SUNNICA ENERGY FARM
DCO EXAMINATION
COMMENTS ON STATEMENTS OF COMMON GROUND

SAY NO TO SUNNICA ACTION GROUP LTD
28 NOVEMBER 2022

Landscape Briefing Note 8

Project: 1186 Sunnica PVD
Date: 25th November 2022
Purpose: Review and comment on additional matters requested by Daniel Kozelko
Reference: 1186 BN08 Sunnica PVD Comments for Deadline 3a.docx
Author: John Jeffcock CMLI

Drawing file: EN010106 / EN010106-001964-SEF_ES_6.3_Figure 10-11f ZTV with Barriers Combined.pdf

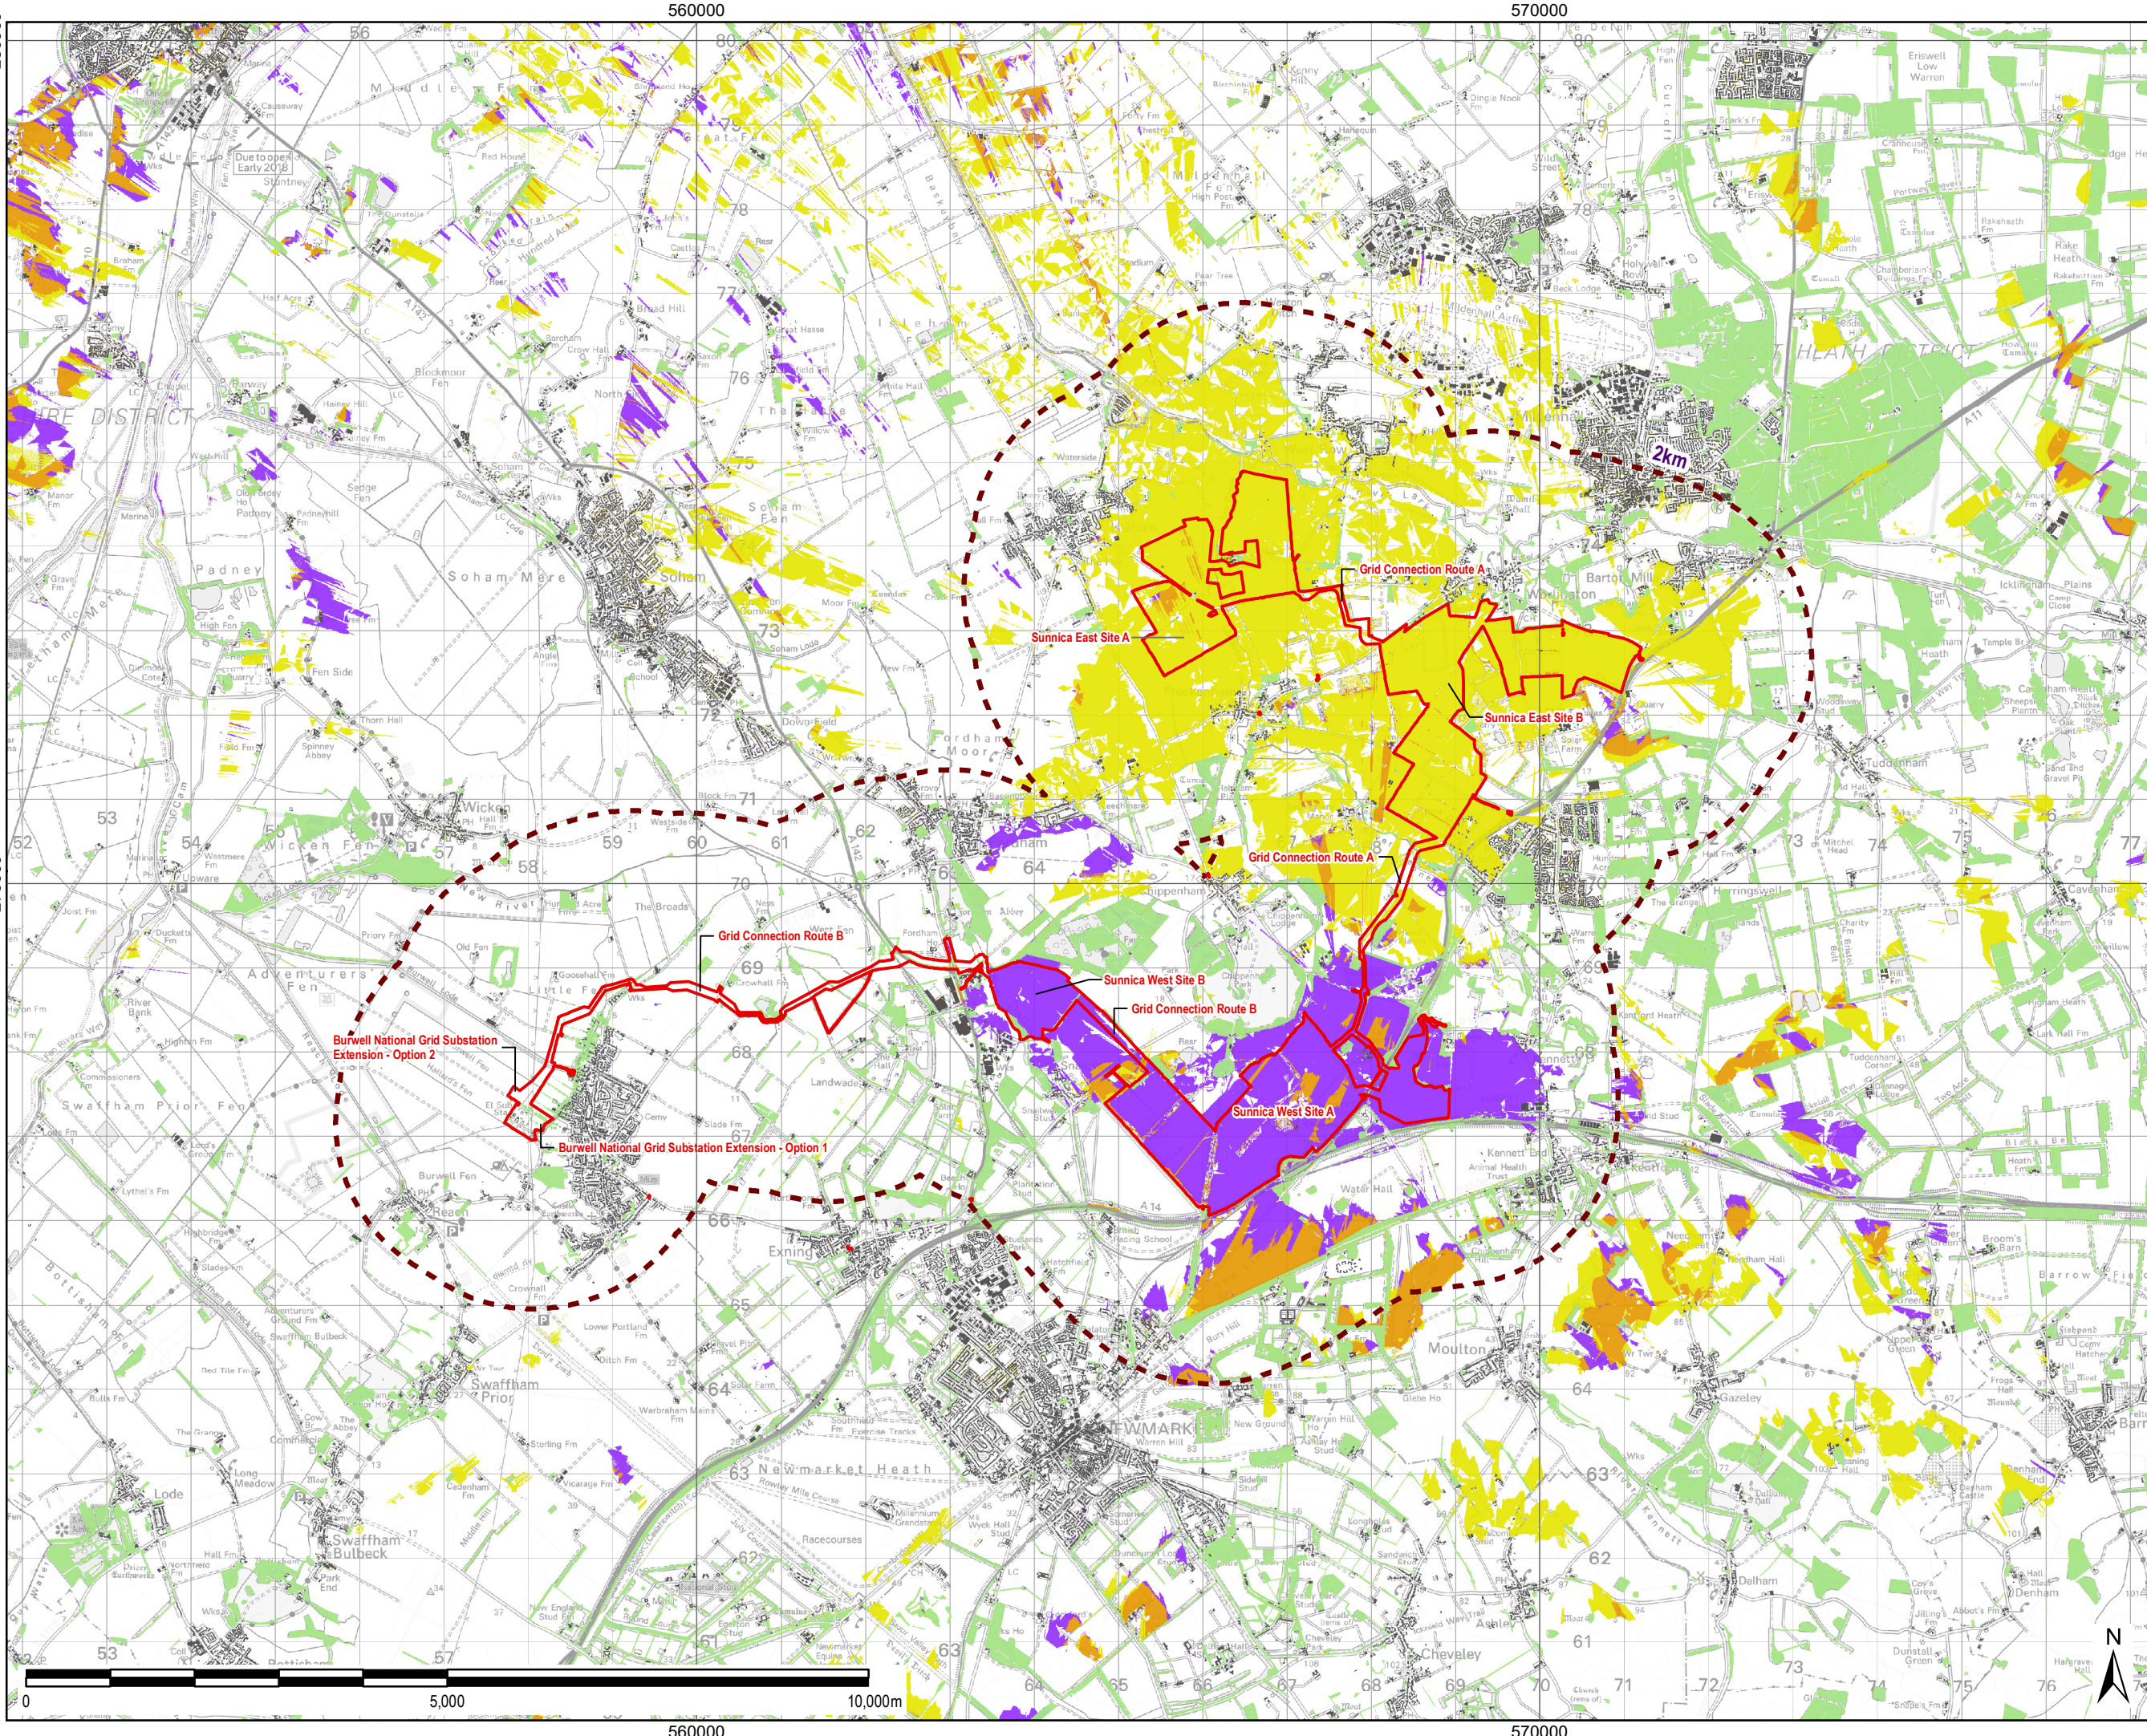
9. Figures 10-11f ZTV with Barriers Combined & Figure 1f Equine ZTV with Barriers Combined. The combined equine ZTV is not significantly different to the non-equine combined ZTV. The Limekilns is the location where the largest block of potential visibility of both schemes is shown. Although Sunnica East is theoretically visible from the Limekilns, given the distance and additional screening provided by elements not considered in the ZTV, its impact from this location would be negligible.

Drawing file: EN010106 / EN010106-003679-Figure 1f Equine ZTV with Barriers Combined.pdf

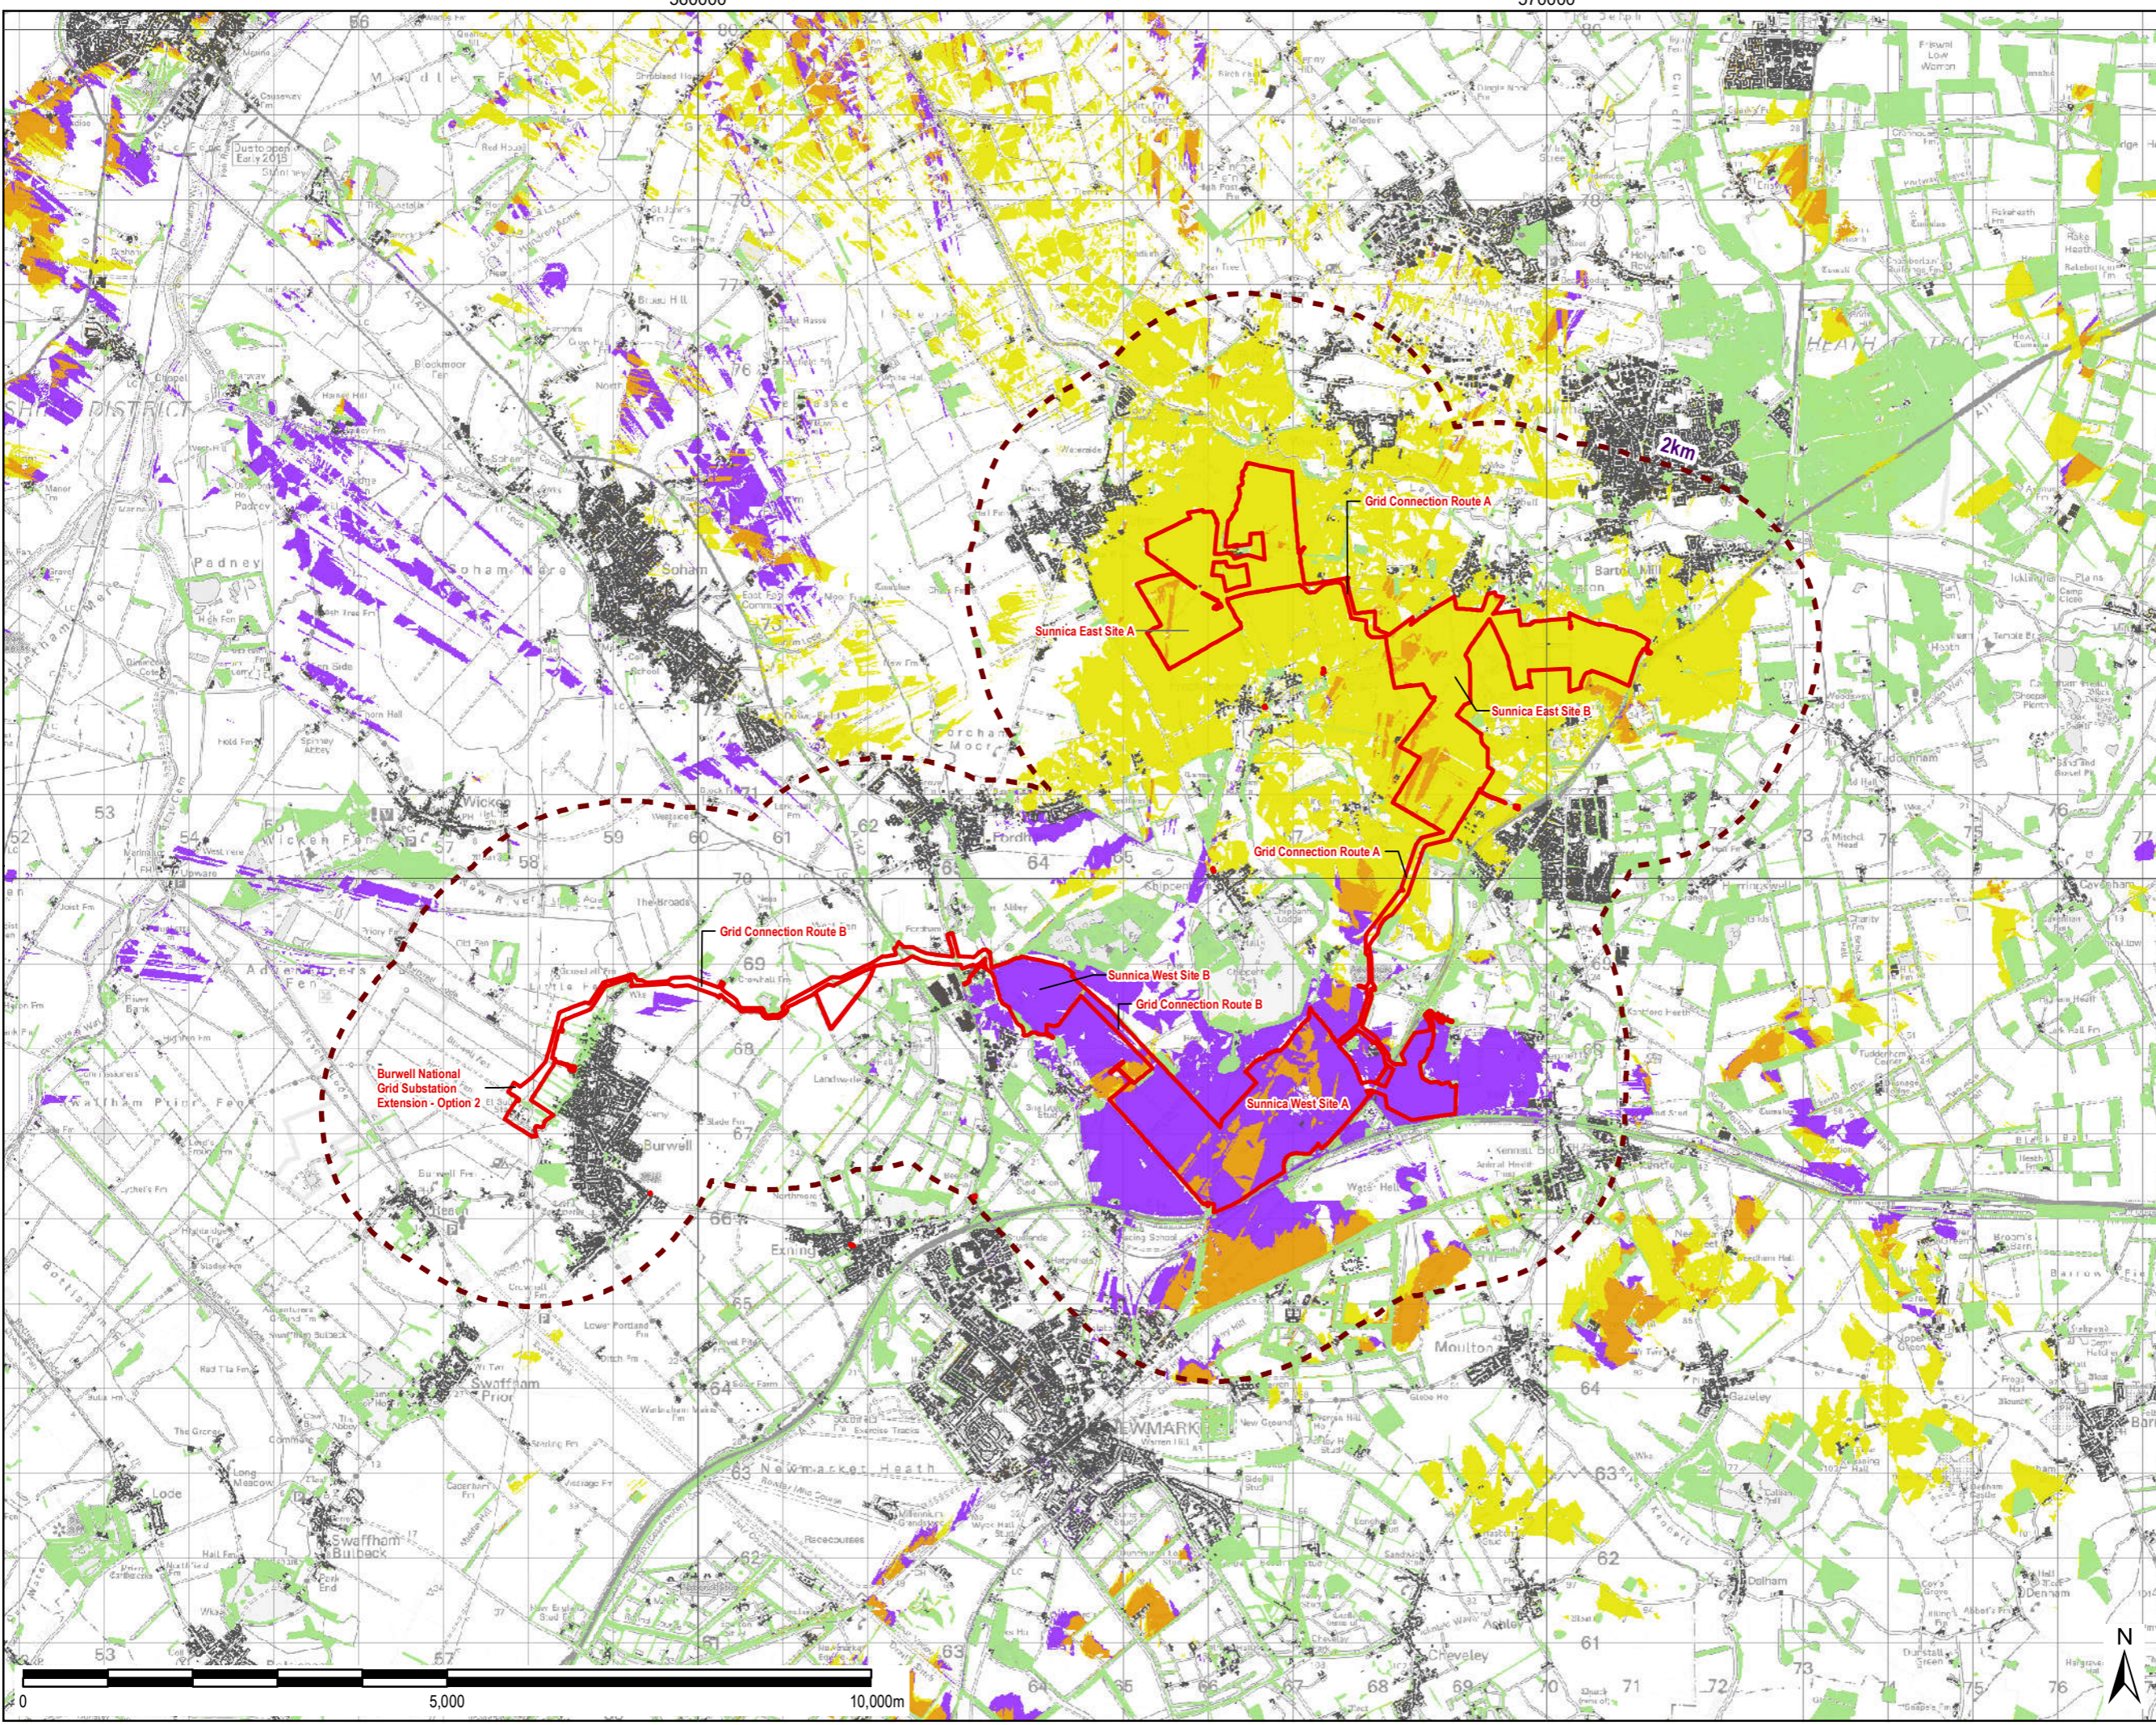
6. Equine ZTVs have been submitted which identify locations where the development would theoretically be visible to people on horseback, for which an assumed eye height of 2.7m was used.

7. As expected, the 'equine' ZTVs show more locations where the development would theoretical be visible than the ZTVs prepared for an assumed eye height of 1.7m (e.g., people walking in the landscape). At the scale presented, the increase in locations does not appear to be significant, particularly within the 2km study area. However, presentational issues mean that it is difficult to pinpoint areas where the changes might be significant e.g., additional visibility on bridleways. The presentational issues which mean the results of the ZTVs are difficult to interpret are:

- The large scale at which the figures have been presented.
 - Insufficient transparency used on the colour blocks means the base mapping beneath is difficult to read.

- Due to the large scale and poor quality of the base map, names of settlements and roads are difficult to read.
 - Public rights of ways are not legible.

-
8. The extent of the development that would be visible at any given location cannot be determined from the ZTVs. Therefore, it is not possible to determine from the ZTVs whether people on horseback would see a greater extent of the development than people walking in the landscape, but it is reasonable to assume that they would. This issue is expected to be more significant for equine receptors than the increase in locations of visibility shown on the ZTVs, which as above, doesn't appear to be significant.
